Your Ref: OWPC21525
Our Ref: BR/302/18/PL 21-11-2018
Please ask for:
Richard Castro-Parker

1 x 2 bedroom flat and 2 x 1 bedroom flat to the east elevation
73 Hawthorne Road Bognor Regis

Thank you for your internet representation made on 20th February 2019 which has been recorded as '**an objection**' with the comments as follows:

SITE PLAN (Proposed) @1:200

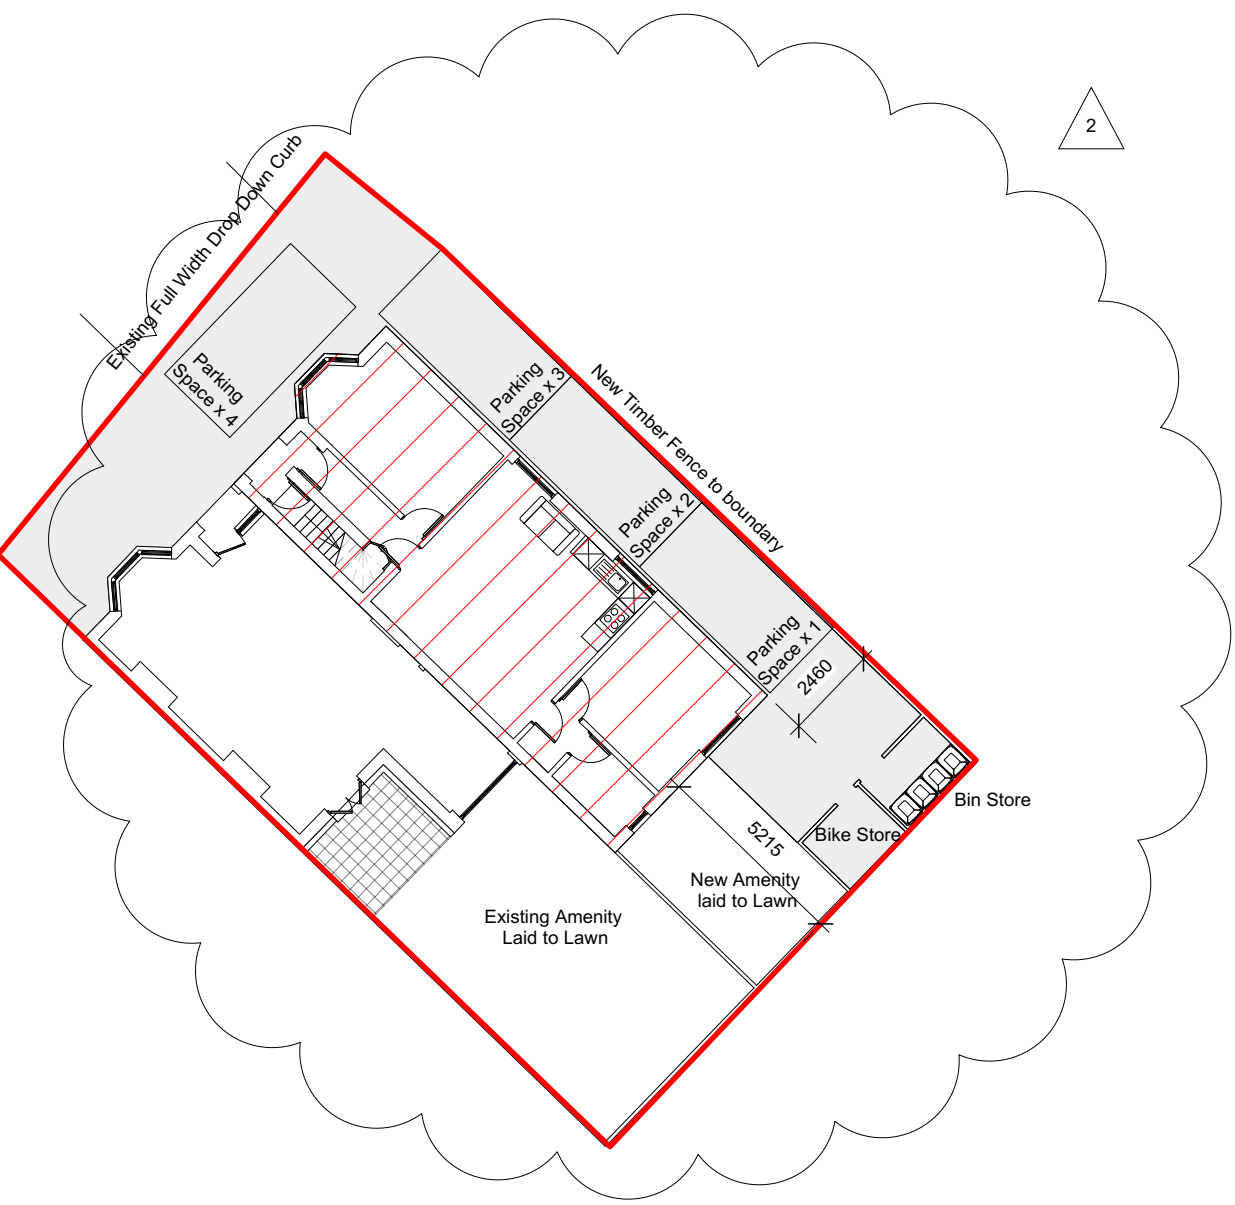
- 1. The site plan refers to 71 Hawthorn (no e) Road, not 73.*
- 2. Too many units for this site - already problems with parking on the road and parking on the double yellows along by this site.*
- 3. Run off is high from the concreted area.*
